## Lead Local Flood Authority

Date 30 October 2024

### RE: F/14/24/RES – Land at Ford Airfield, Ford, West Sussex

We **object** to this planning application in the absence of an acceptable Drainage Strategy relating to:

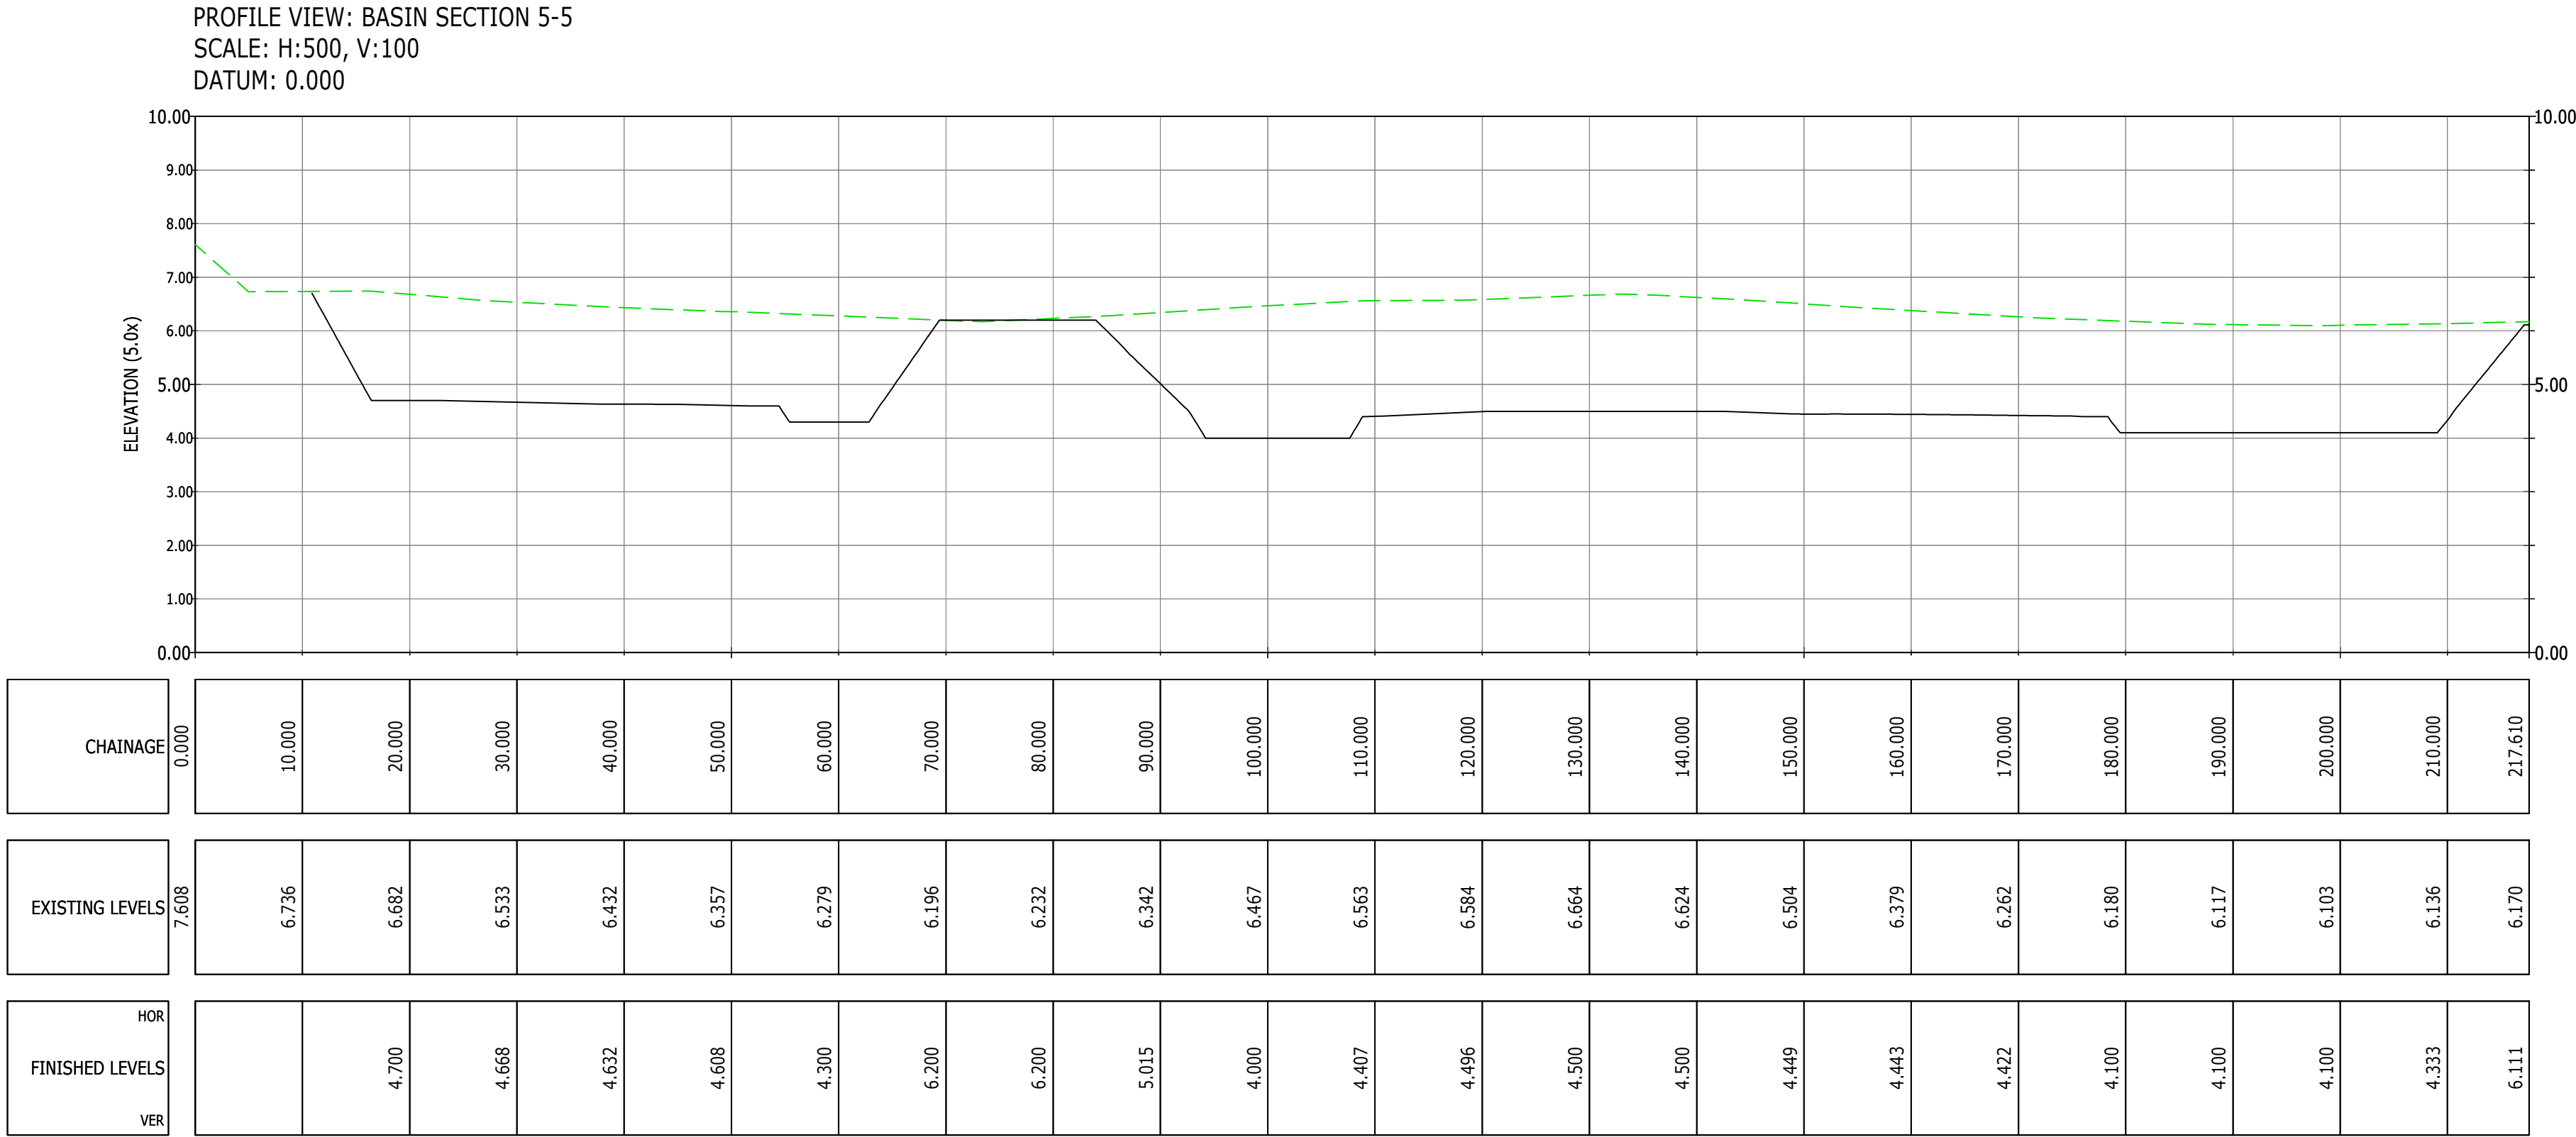
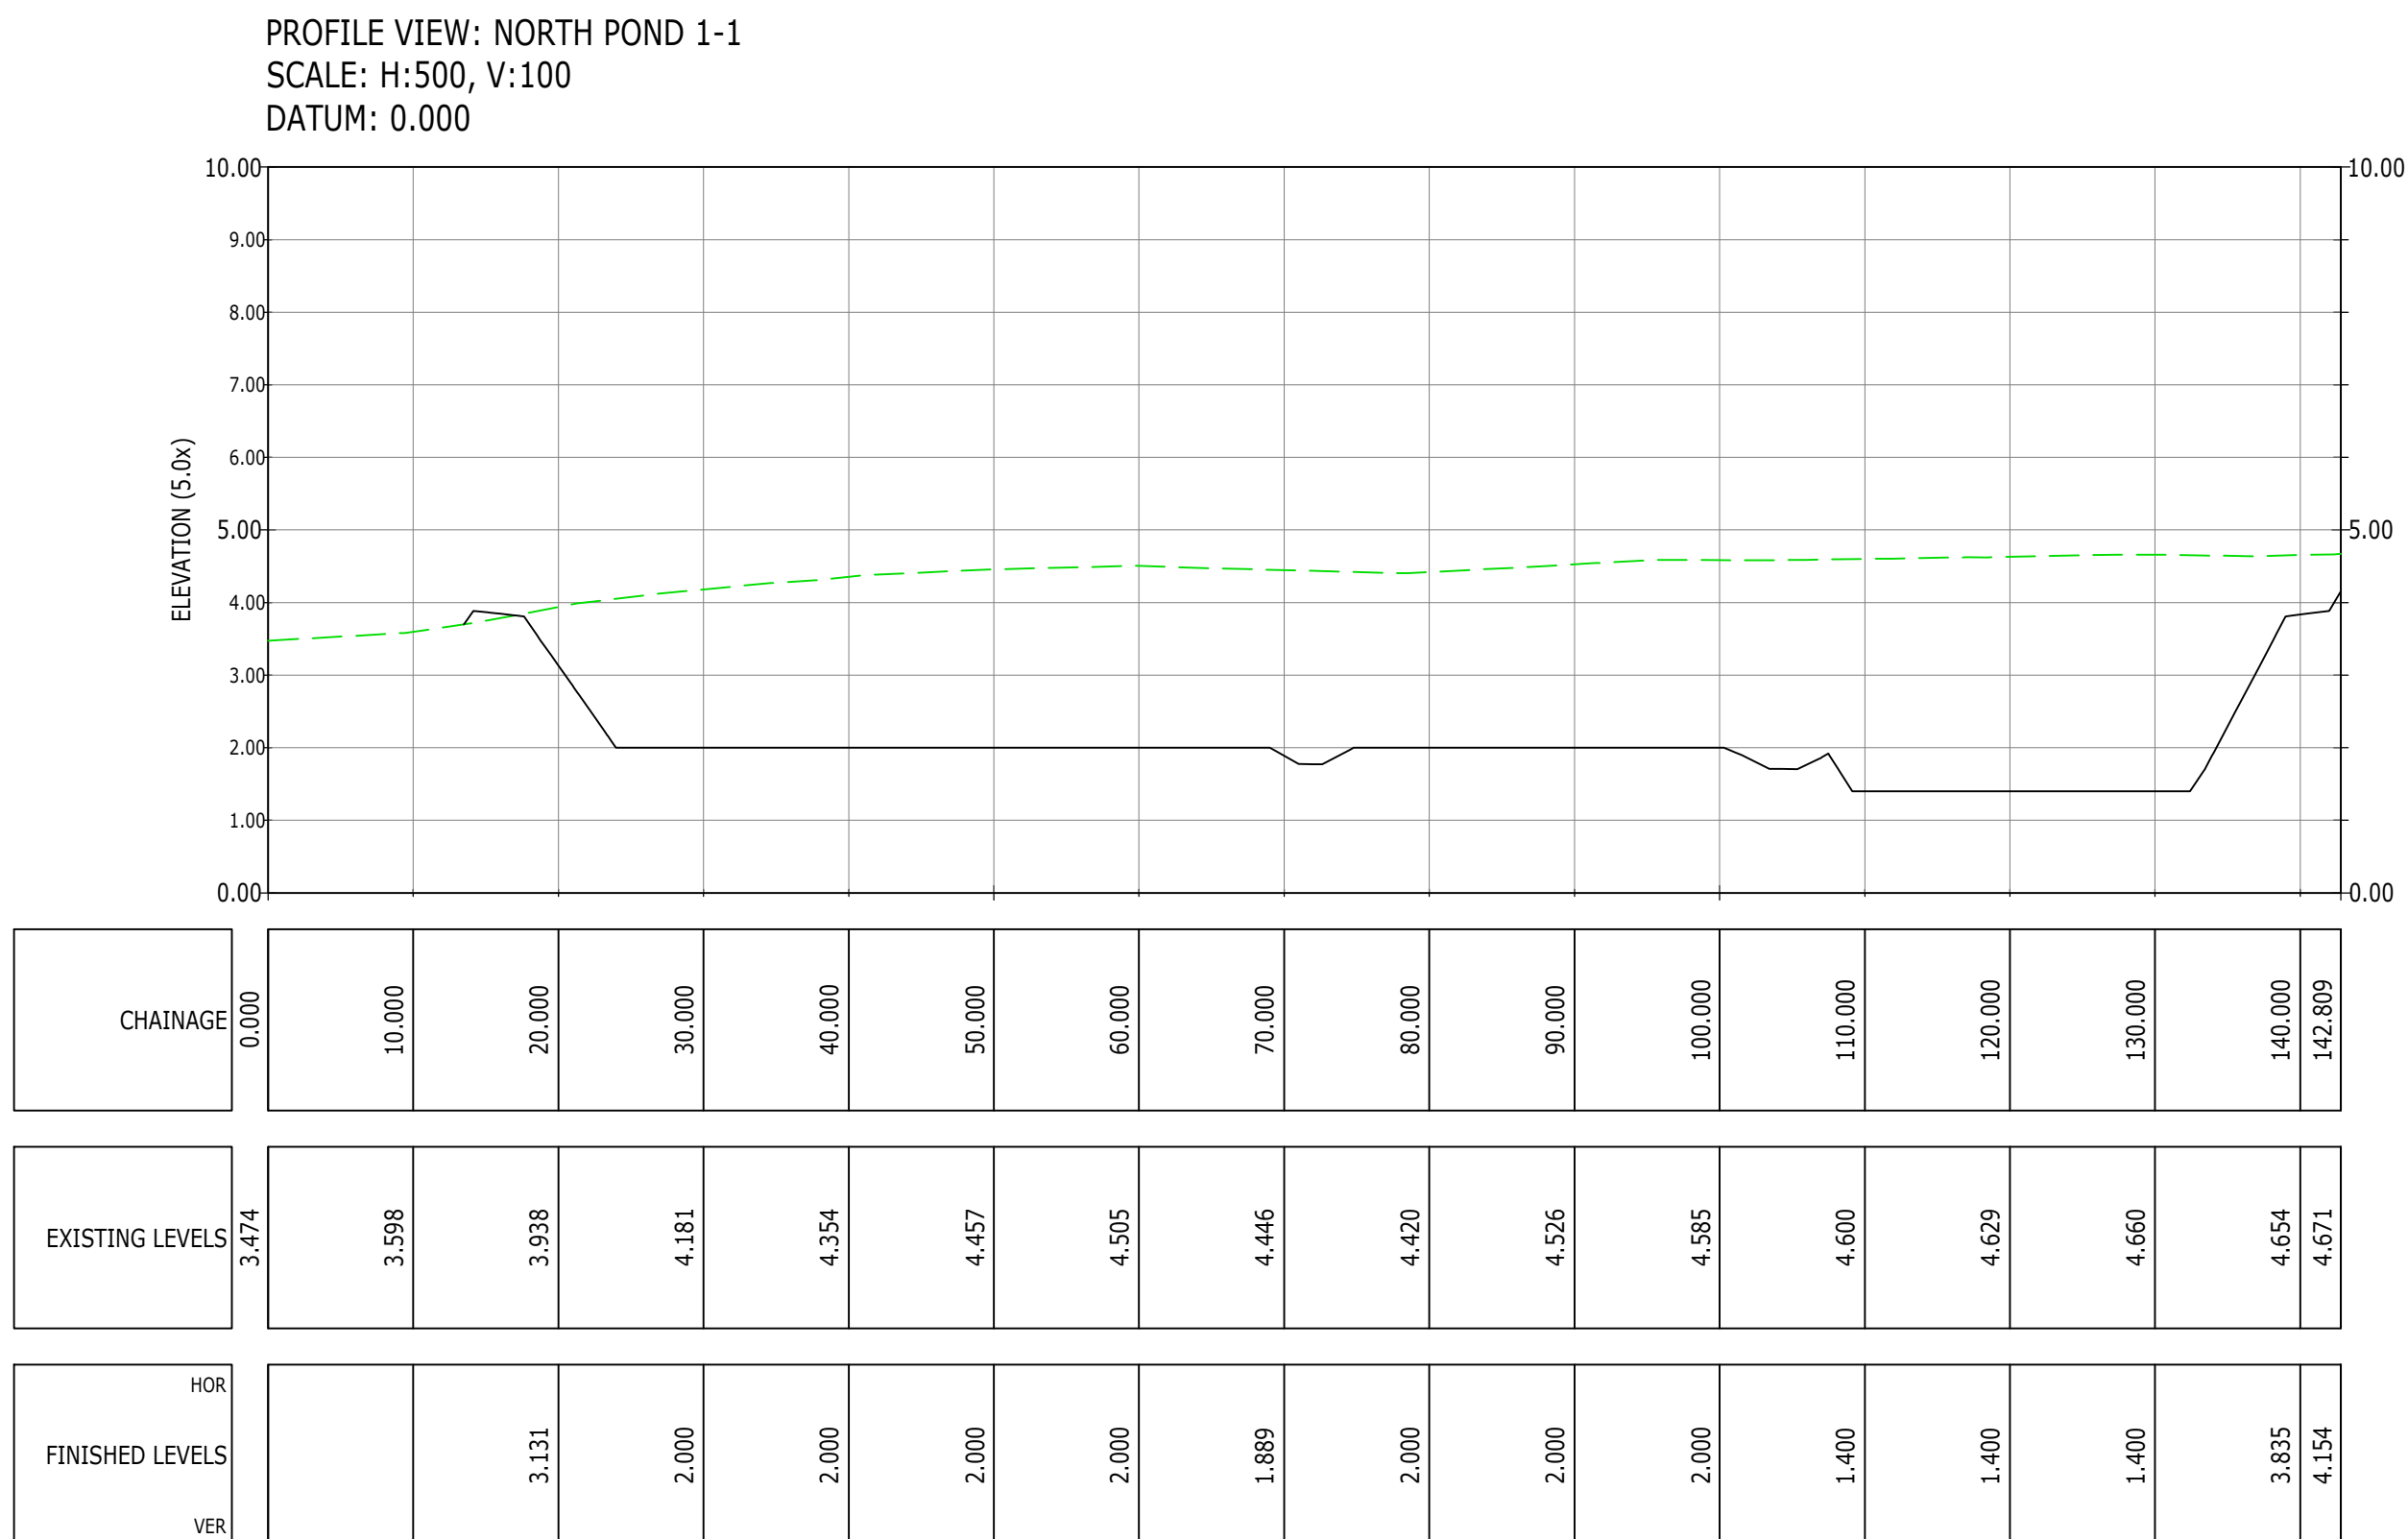
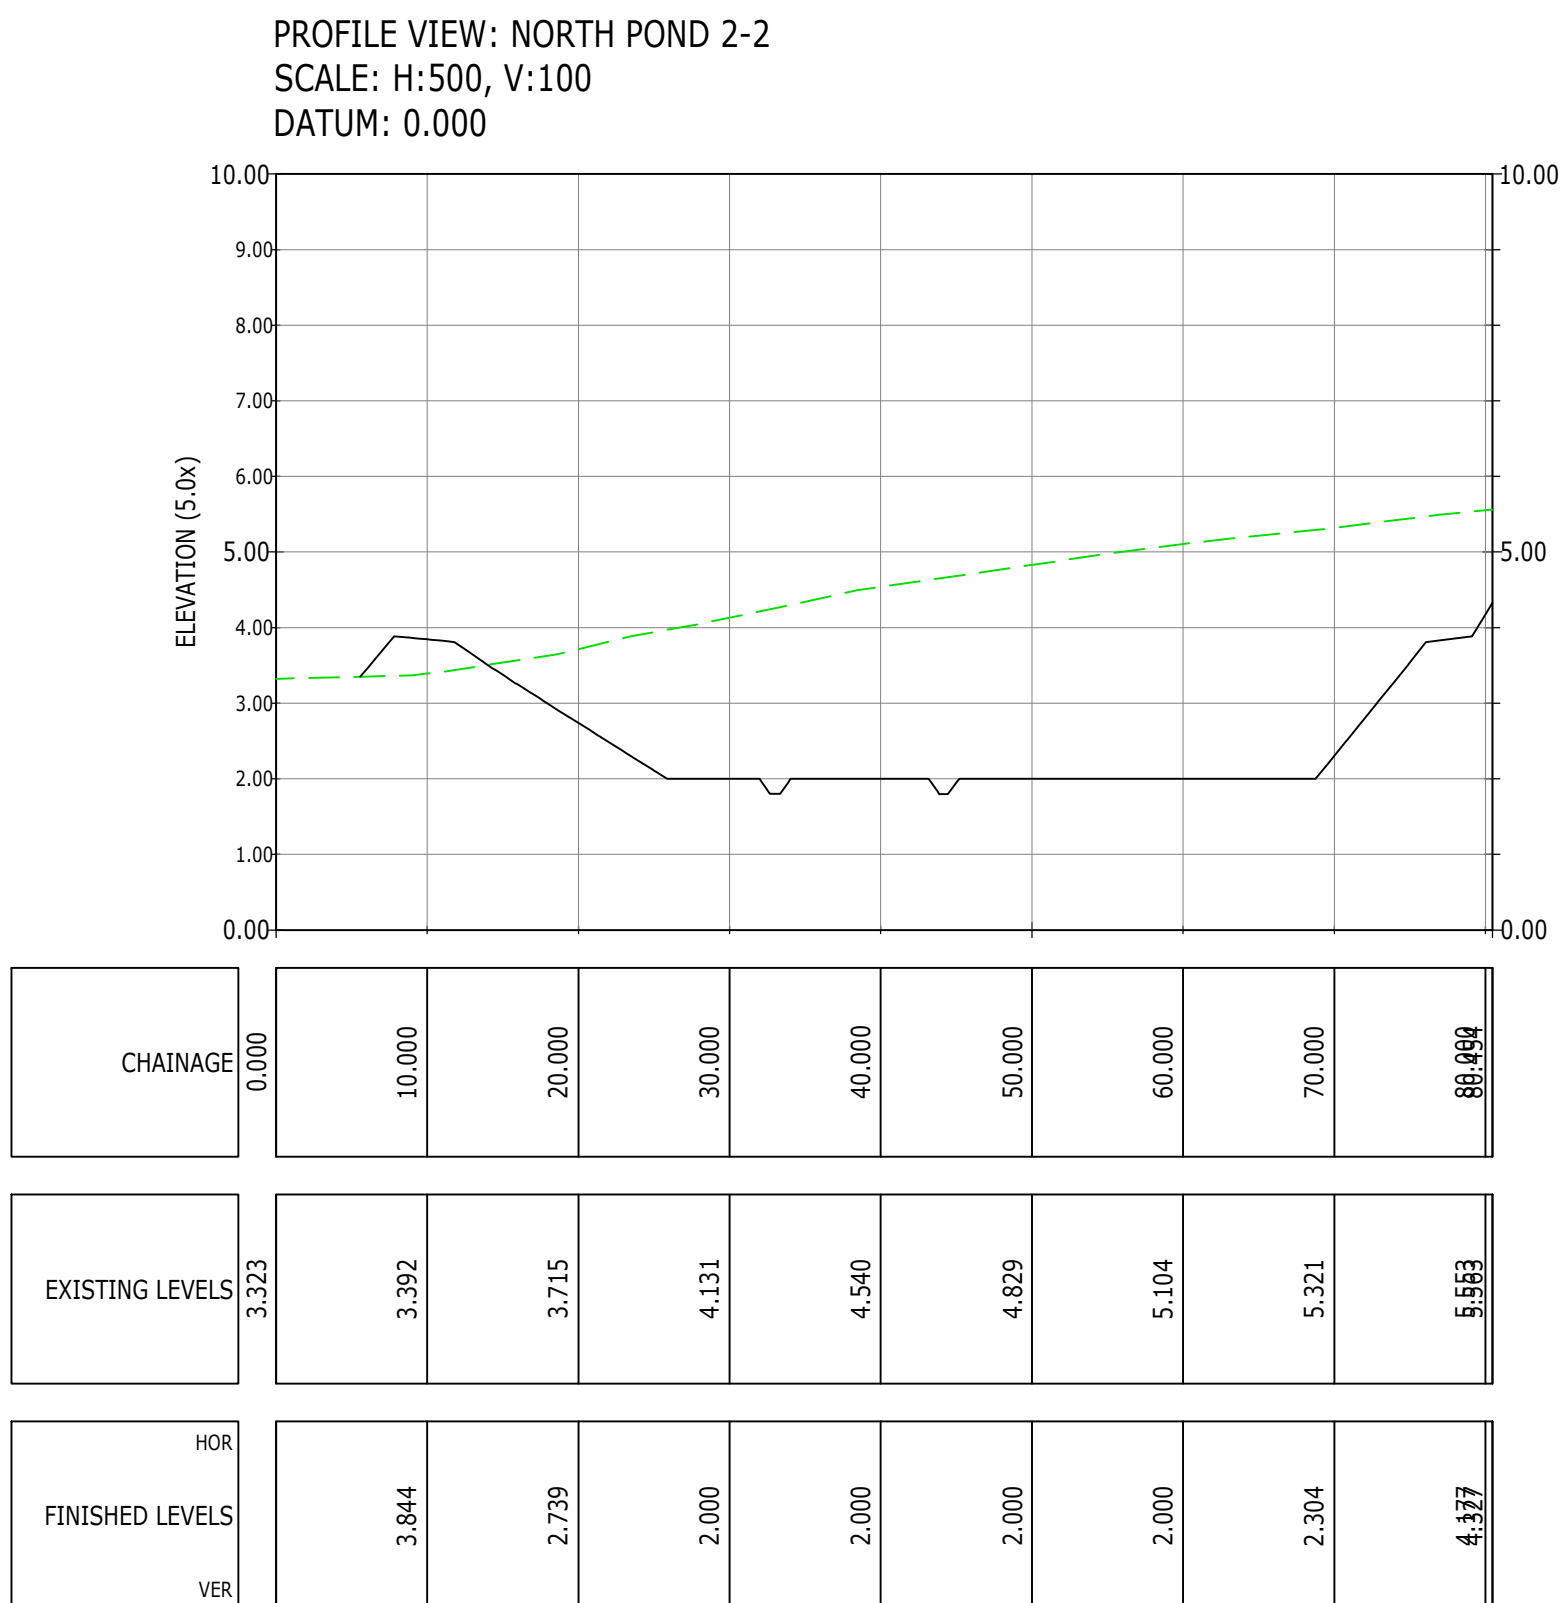
2. The high groundwater levels will also need to be considered in detailed design of attenuation structures. 1m buffer (finished level and water level)

7. Easements 3m from the top of the bank on both sides of any watercourses and the basins are required for maintenance access. Off road parking for maintenance vehicles is also required. Updated plans should reflect these requirements and be sufficiently and clearly annotated.
